CITY OF ALBUQUERQUE

July 22, 2019

Re: Mountains Townhouse
1406 Mountain Road NW
Traffic Circulation Layout
Engineer's/Architect's Stamp 07-16-2019 (J13D209)

TRAFFIC CIRCULATION LAYOUT
APPROVED

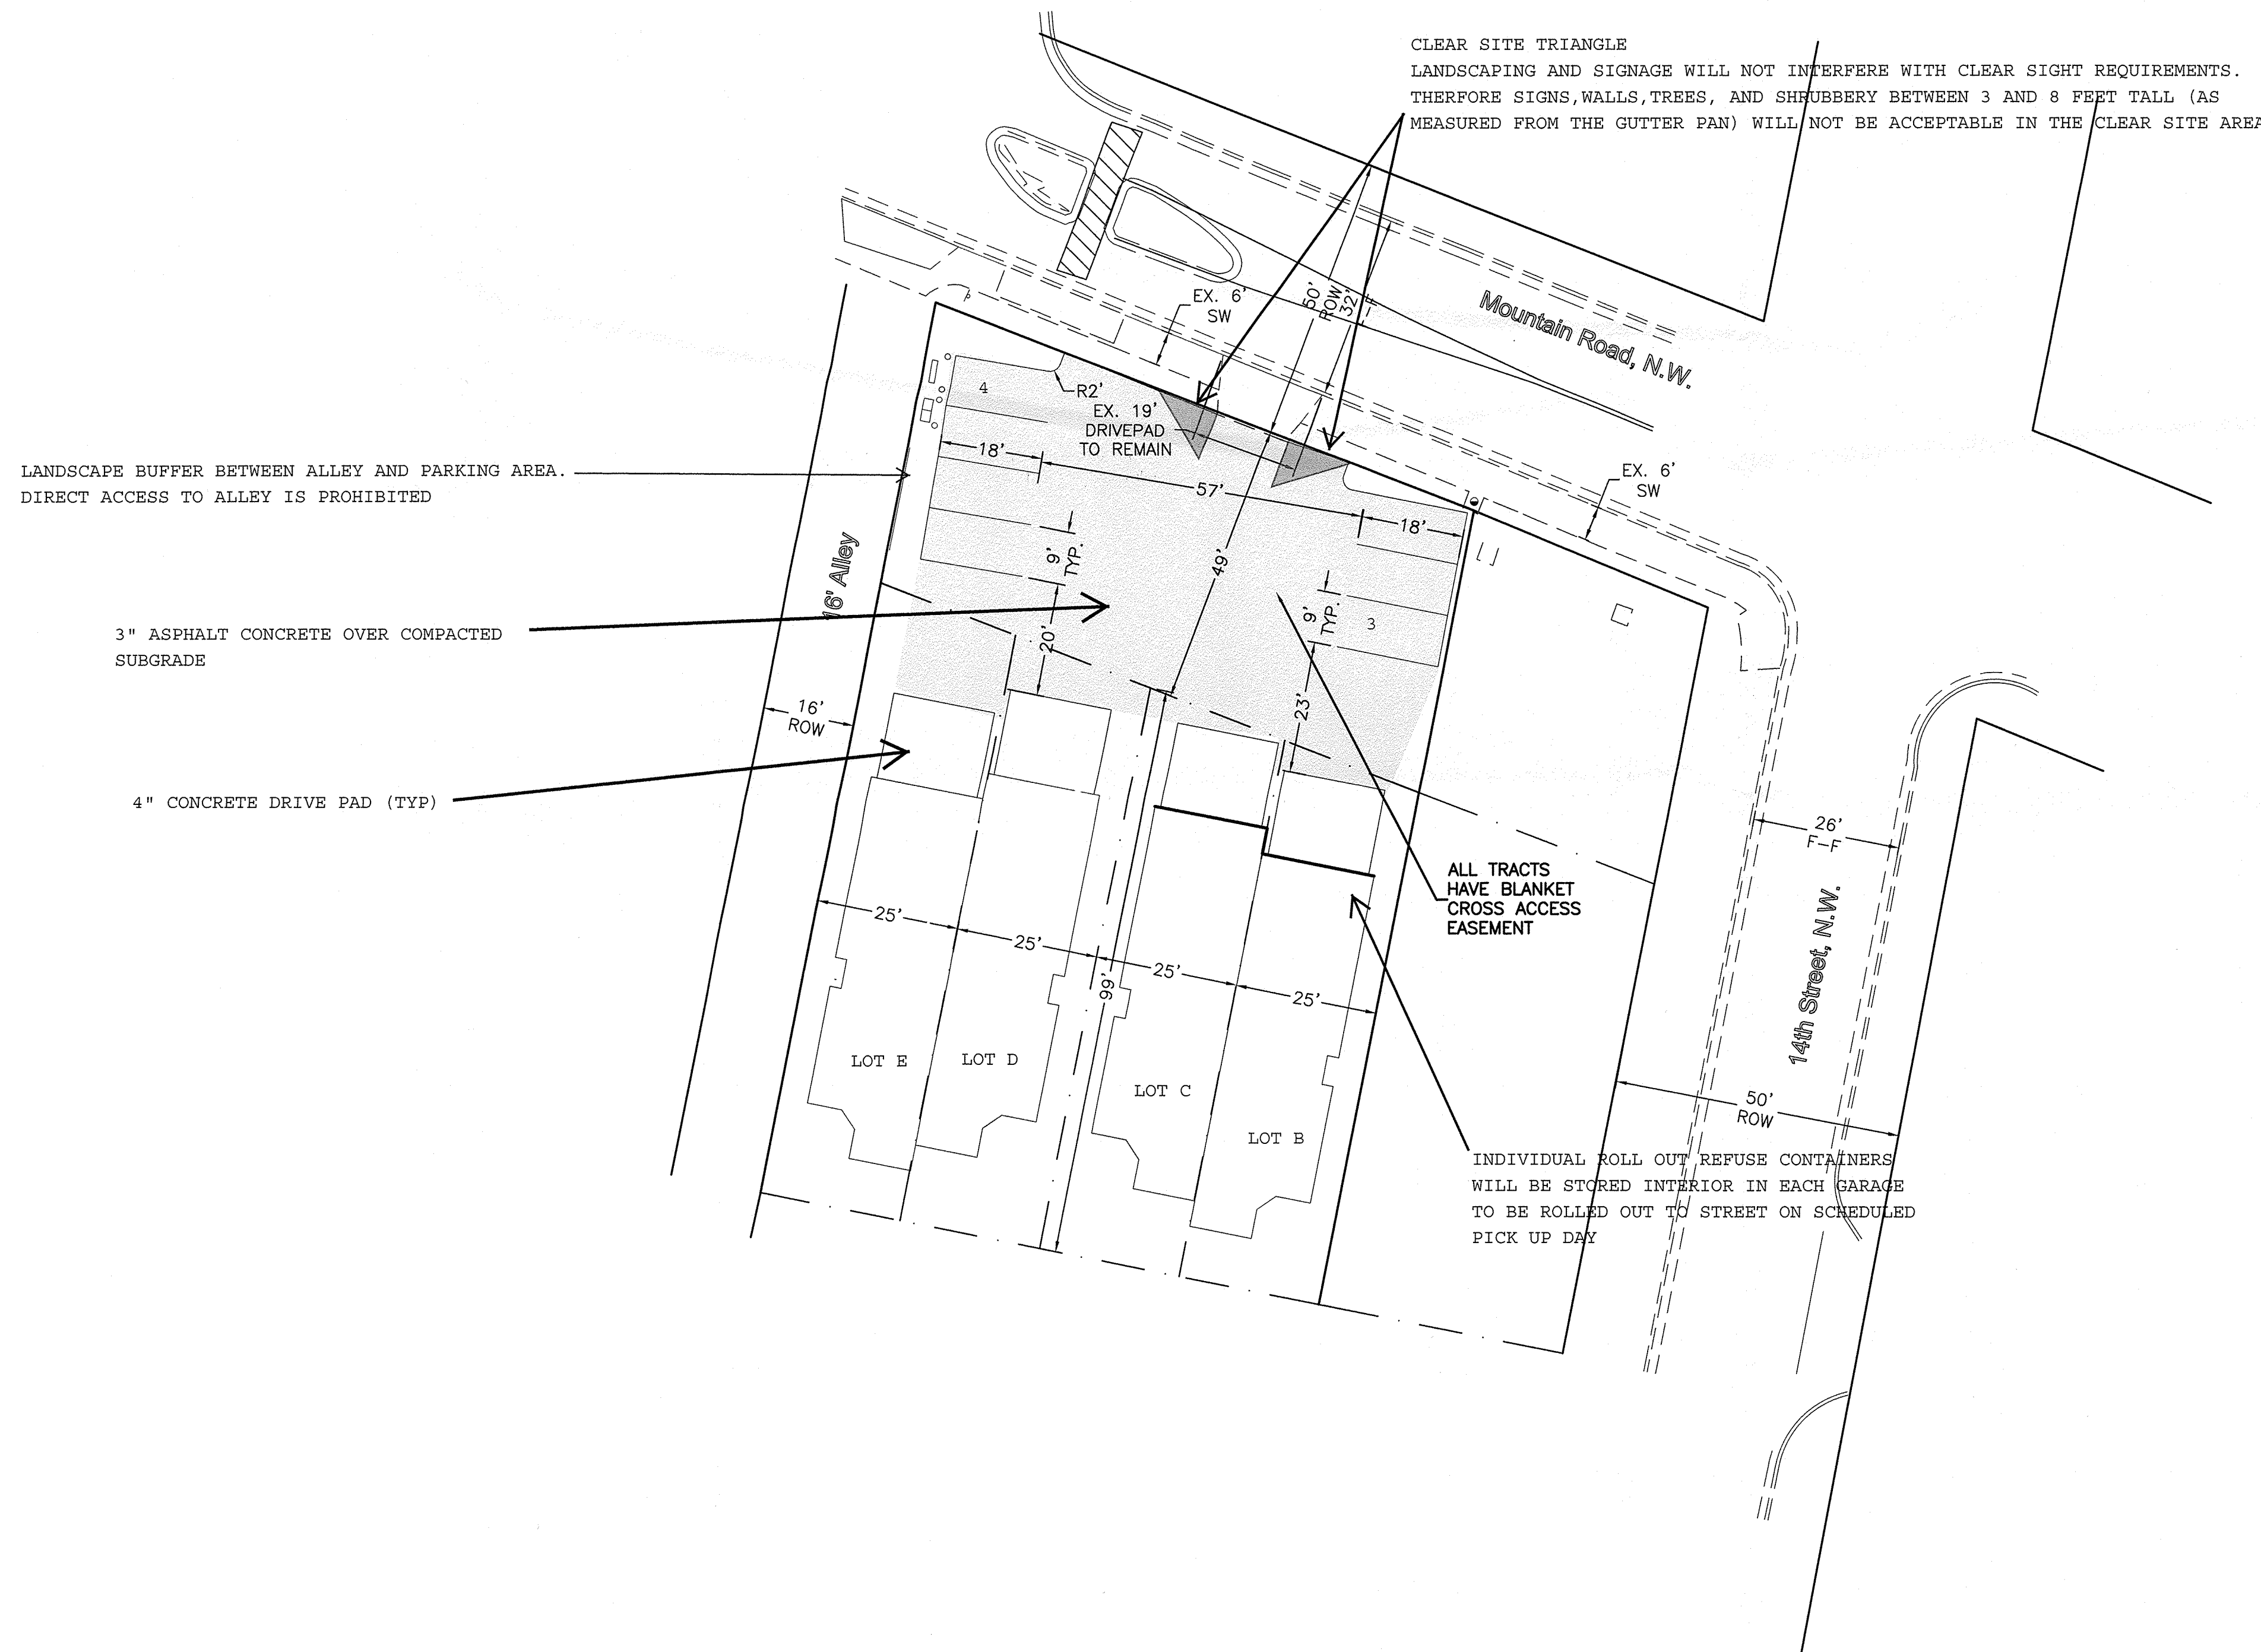
1. It is not apparent what type of pavement surface is being proposed. A hard driving surface will be required as part of this proposed project for parking area and drive aisles.
2. Show the clear sight triangle and add the following note to the plan:
"Landscaping and signage will not interfere with clear sight requirements. Therefore, signs, walls, trees, and shrubbery between 3 and 8 feet tall (as measured from the gutter pan) will not be acceptable in the clear sight triangle."
3. Please include a copy of cross access easement.
4. Please show the location of the refuse tank.
5. Is alley being used for an access? If yes, it needs improvement.
